Your ref: SSD 3799 Mod 1
File no: MC-14-2312

Project: SSD 3799 Mod 1 Marsden Park cold storage facility

Re: Council comments for the further Response to Submissions

DRAWING TITLE
PROPOSED ELEVATIONS

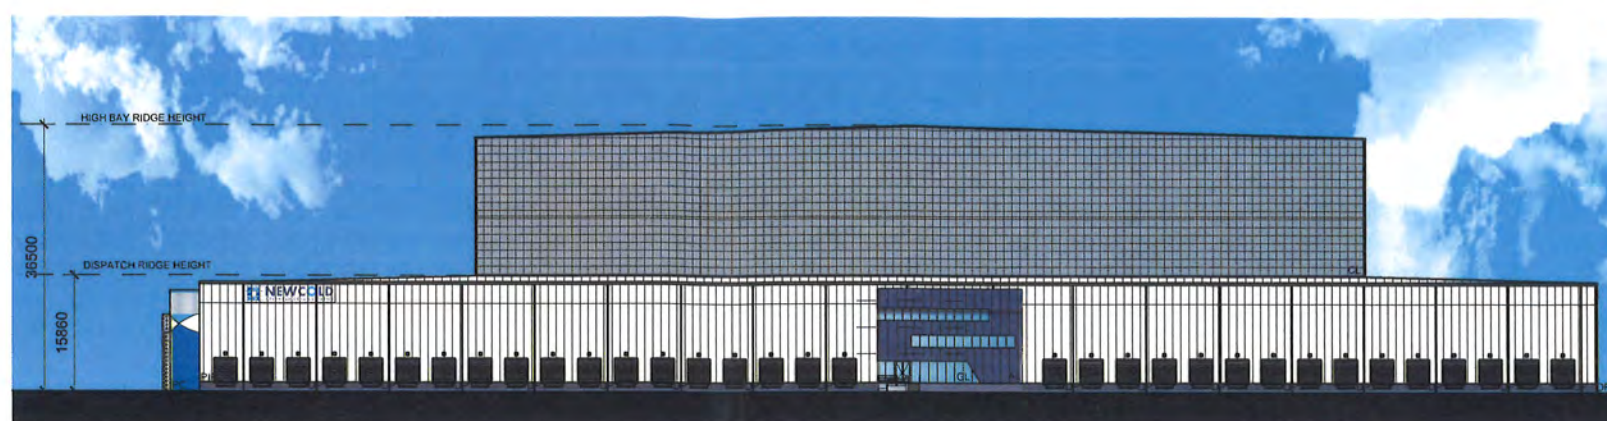
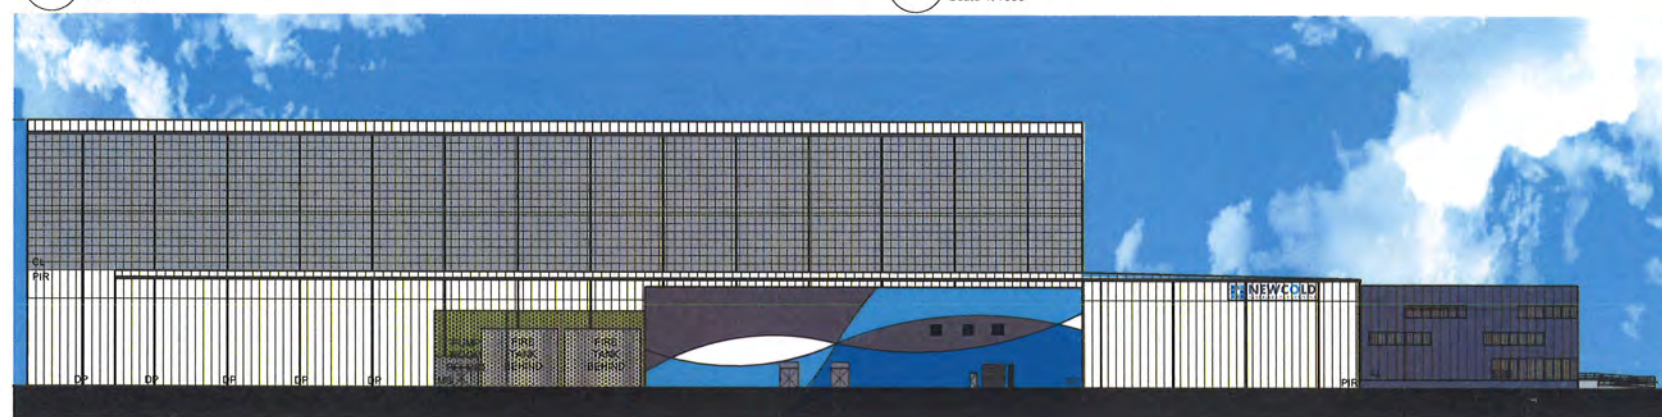
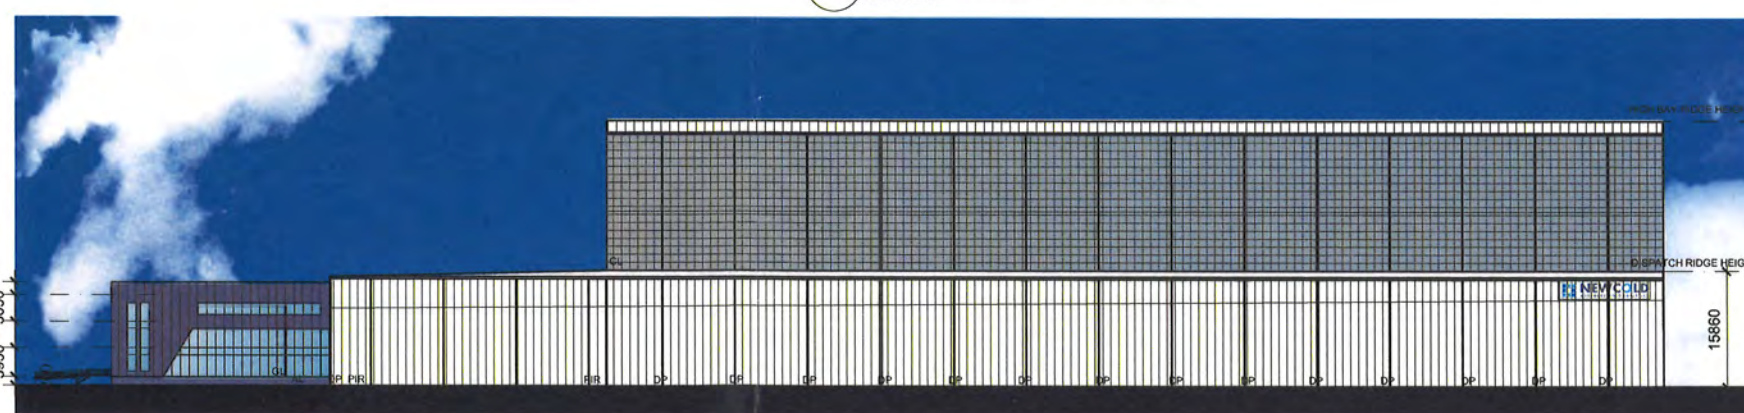
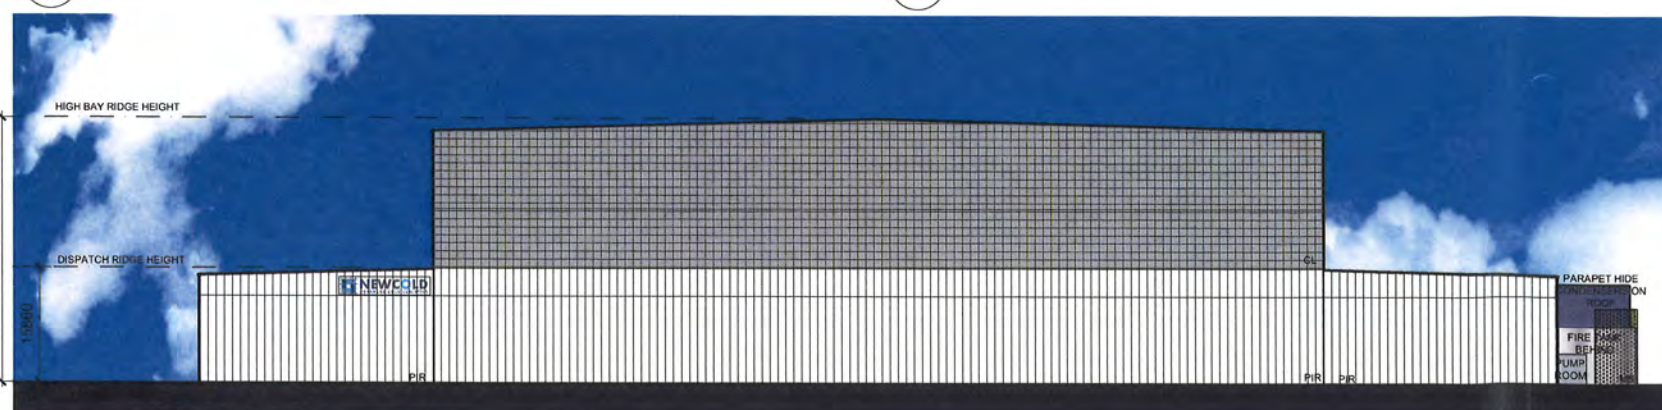
We consider both Options 1 and 2 to provide a satisfactory outcome for this development. I note that our City Architect has expressed a preference for Option 2.

It is our opinion that the proposal consists of an extensive portion of the building footprint which substantially exceeds the height of building development standard for this site, even in comparison to other high bay warehouses. However, the quality and design of the revised external materials is considered to offer a built form which is closer to being consistent with the desired future character of the Marsden Park Industrial Precinct plan. Therefore, we do not object to this application given the installation of the external treatments provided in the correspondence dated 12 December 2017.
